EPC STORMWATER REVIEW COMMENTS
IN ORANGE BOXES WITH BLACK TEXT

**EROSION CONTROL AND
STORMWATER MANAGEMENT PLAN
FOR
FALCON AREA WATER AND WASTEWATER AUTHORITY
(FAWWA)
WATER TREATMENT PLANT**

EROSION & STORMWATER QUALITY CONTROL PLAN FOR FALCON WATER AND WASTEWATER AUTHORITY WATER TREATMENT PLANT

FALCON AREA WATER AND WASTEWATER AUTHORITY - WATER TREATMENT PLANT
GRADING AND EROSION CONTROL PLAN
DESIGNED BY JDP SCALE DATE 3/28/23
DRAWN BY JDP (H) 1"= 30' SHEET 2 OF 4
CHECKED BY KRC (V) 1"= N/A JOB NO. 1307.00

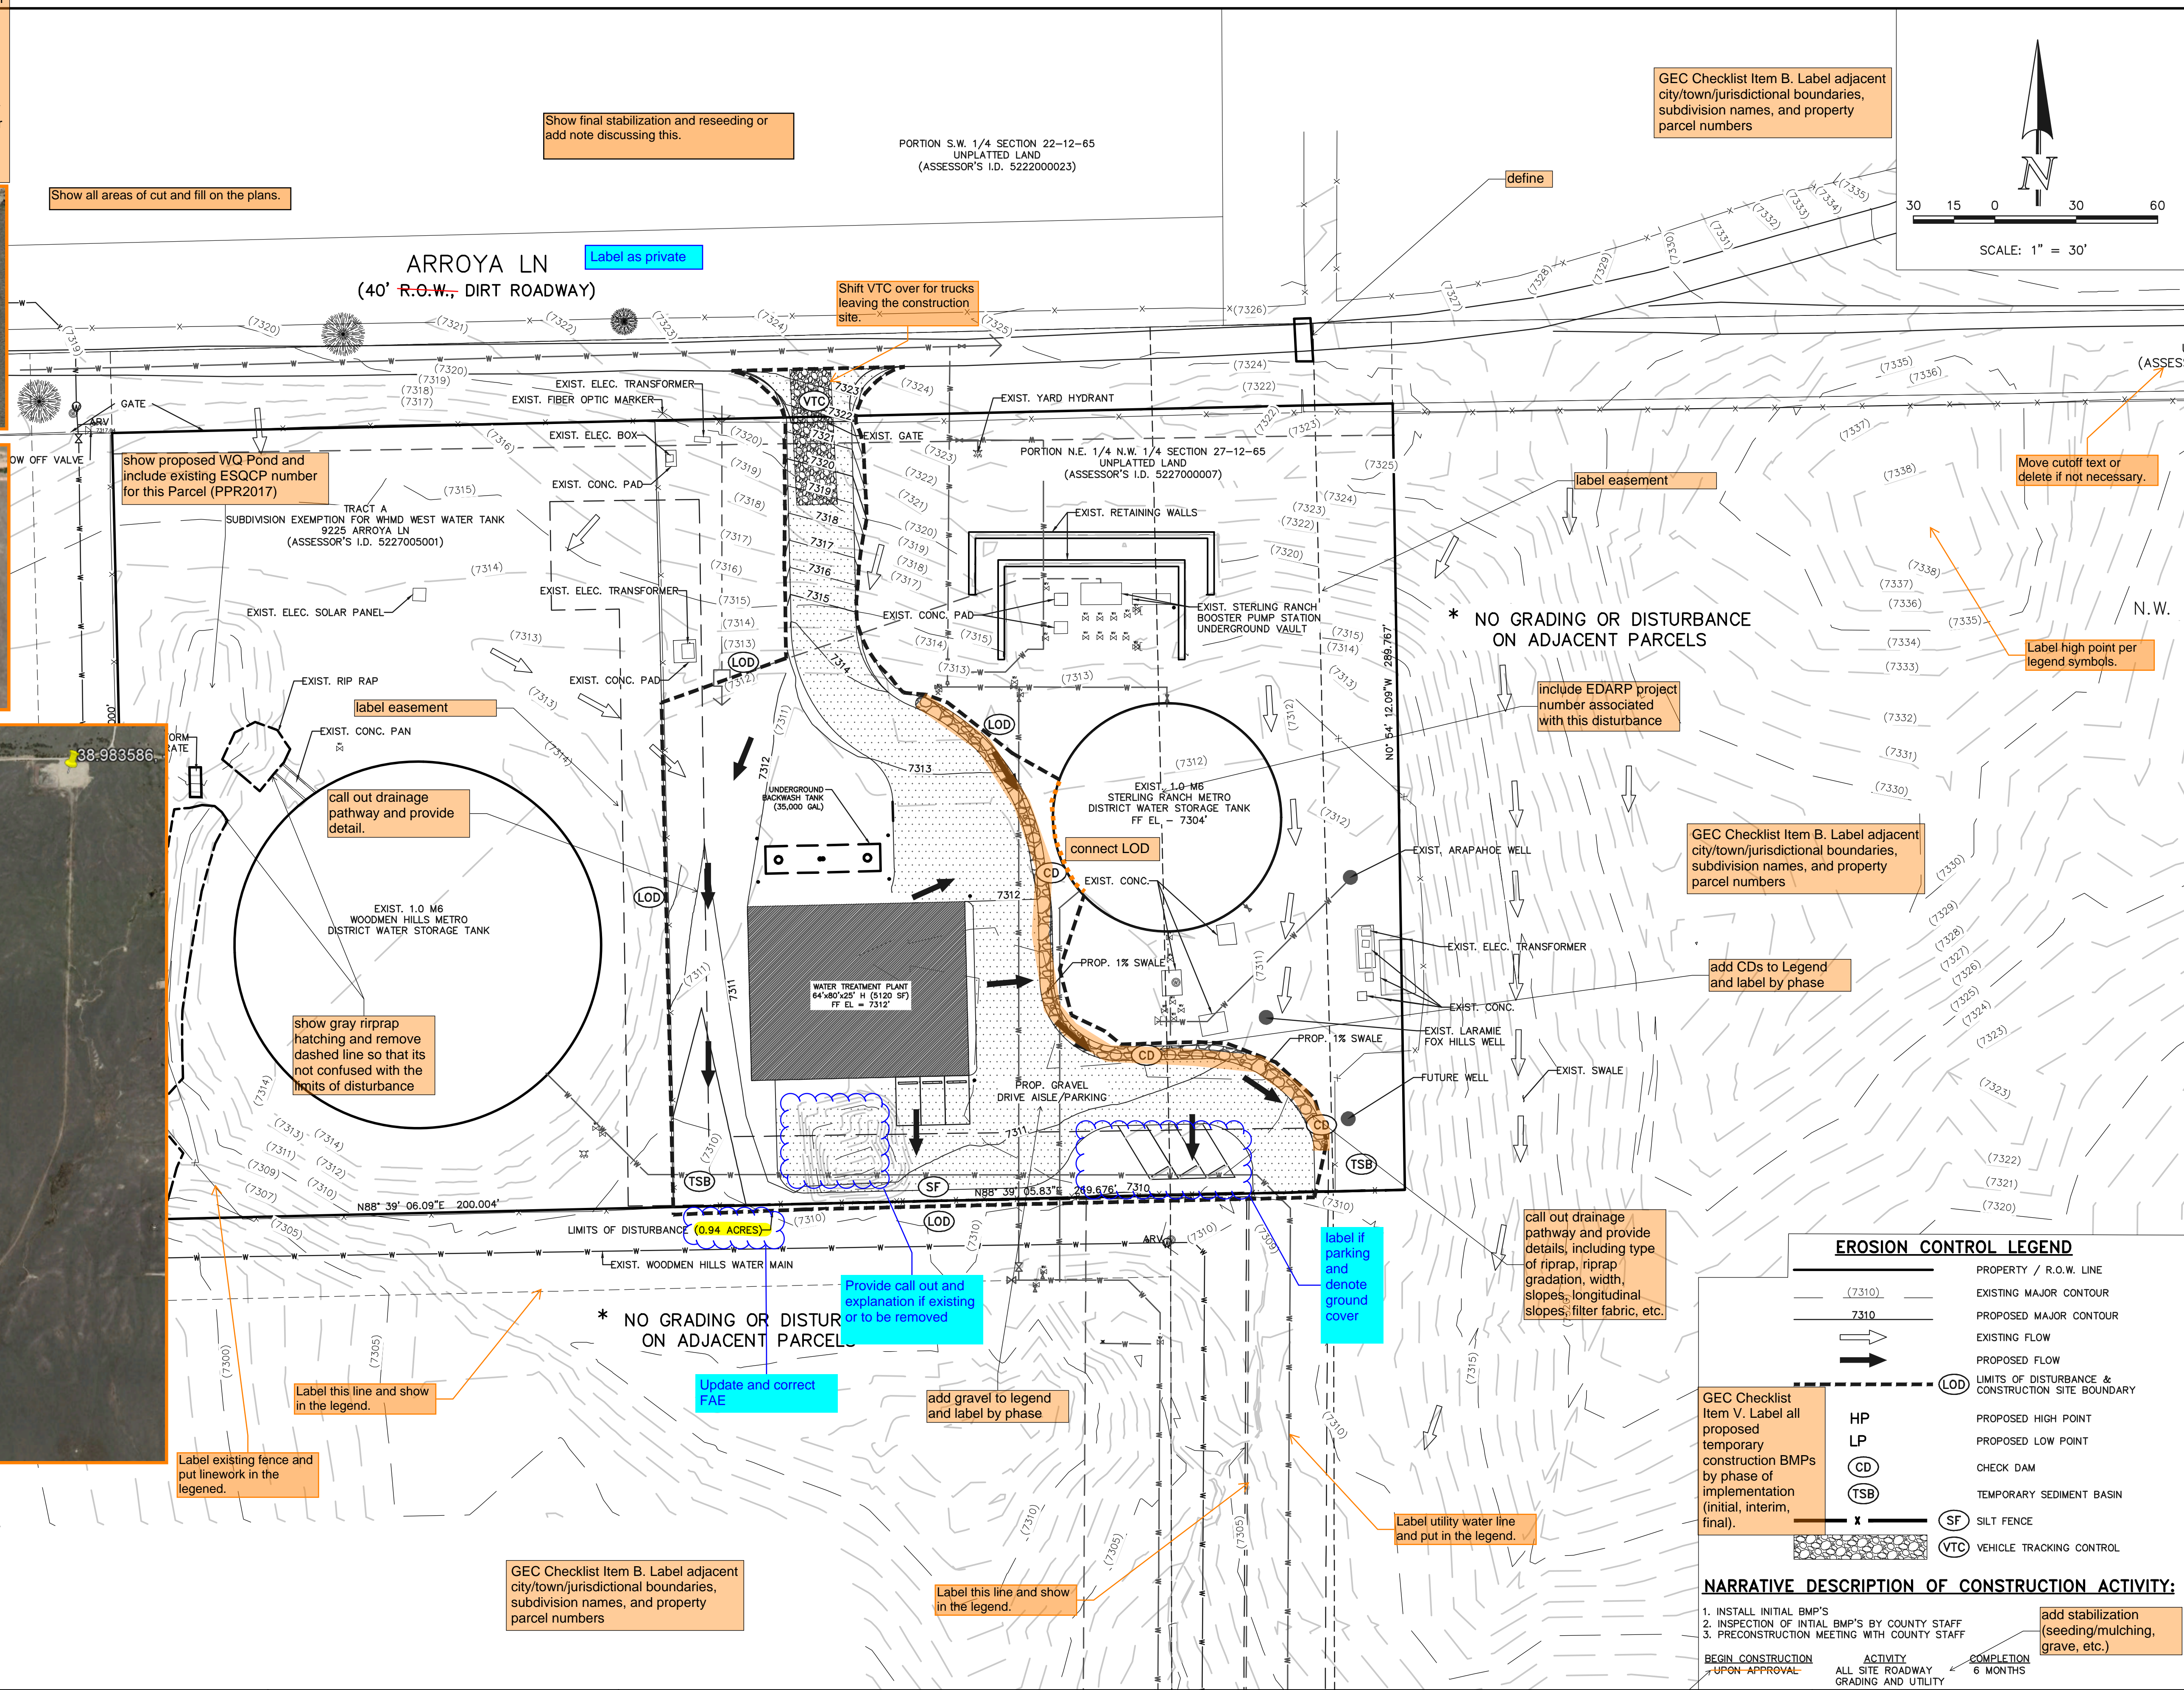
This percentage does not seem to match the disturbance/total area. Update accordingly.
